8th March 2018

Pre-Application Advice

Proposed erection of 27No. Dwellings.
Boweries Barnham Road Eastergate Chichester

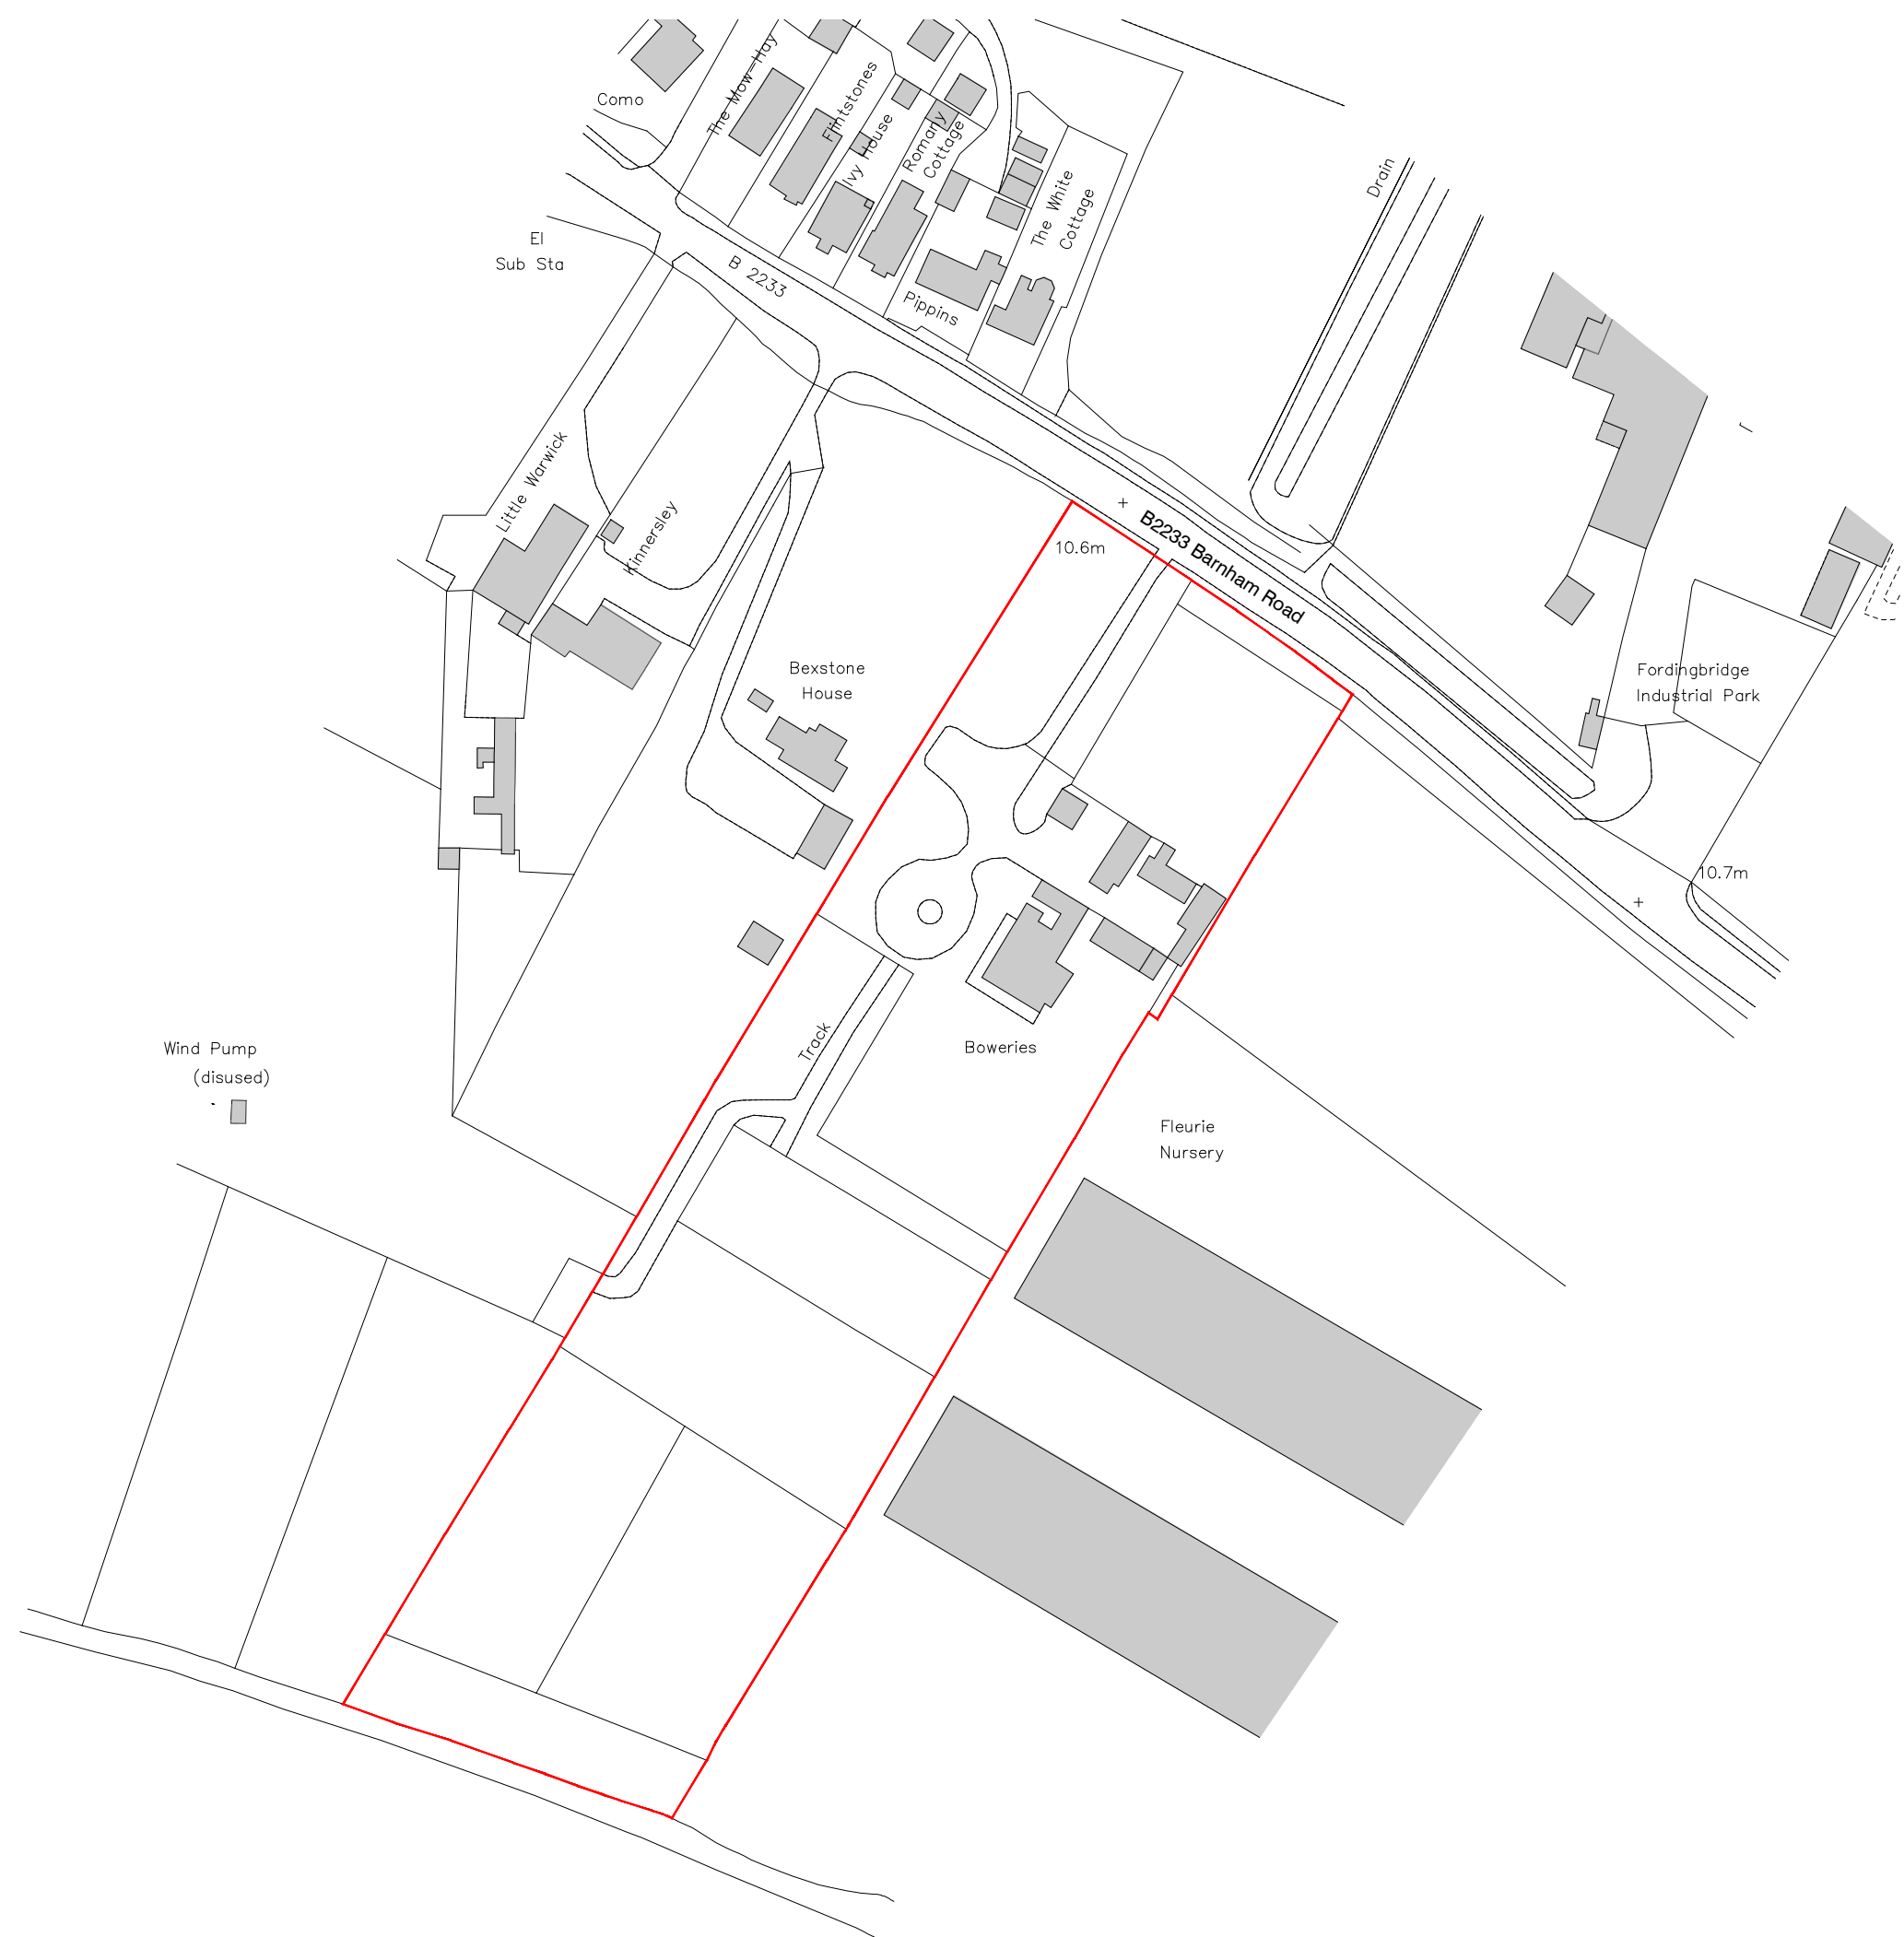
The site is long and narrow which leads to a less than ideal site layout, with properties facing the side fences of other properties and garden fences facing onto the main street. The LEAP is an awkward shaped space to the side of the road. These issues would be overcome and a more acceptable place developed if the site is incorporated into the BEW masterplanning process. This would allow for the site to be designed with adjacent parcels of land, and open up opportunities for designing a successful scheme, rather than a linear cul-de-sac. As set out above, a detailed Masterplan needs to be developed for the site in order to set clear parameters for the design of the site in the context of the allocation.

Policy HDQ8 of the BENP requires good quality private amenity space to be provided. Based on the current layout, I would have concerns about the ability to achieve sufficient outdoor private amenity space for some of the plots shown.
